| Application number: 2025/93126 | |
| What is the application for?: | Demolition of rear block, erection of rear extensions and alterations to existin |
| Address of the site or building: | The Coach & Horses, Eastgate, Honley, Holmfirth, HD9 6PA |

4 Proposed Site Area  
 1 : 200

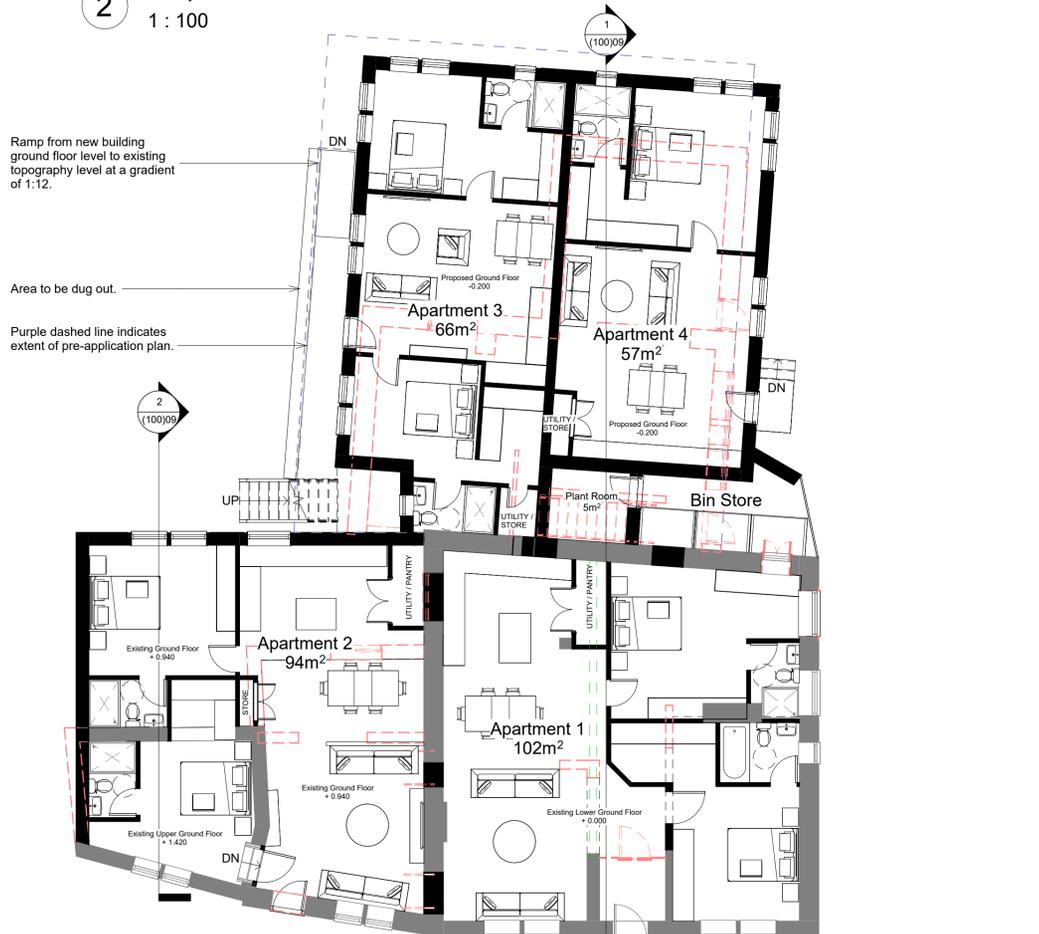
| <p>My objection is that the parking proposed within the planned development will increase both hazardous and antisocial/nuisance parking.</p> <p>River Park is a quiet residential cul-de-sac. It adjoins Eastgate beside the Coach and Horses. This junction has limited visibility. Eastgate is a busy road with "no parking" lines in front of it and for many metres on either side of pub and River Park junction. River Park is narrow with passing places and has continuous "no parking" lines for the first 70 metres from the junction.</p> <p>The proposed development has 9 individual residential apartments, each designed to accommodate at least two people. It also has 9 parking spaces, each designed for a passenger car, (2 of the 9 spaces are designated for electric cars).</p> <p>This 1:1 ratio of parking spaces to apartments is not sufficient if:</p> <ul style="list-style-type: none">• Any of the apartments has more than one car-owning occupant.• Any of the apartments has a car-owning visitor.• Any of the apartments is having trades work done.• Any of the apartments has an artisan occupant with a vehicle larger than a passenger car. <p>There is already a level of nuisance parking around proposed development. At times this is dangerous, for example blocking the public pavement in front of the building, forcing pedestrians, prams, pushchairs and mobility devices onto the main road.</p> | |
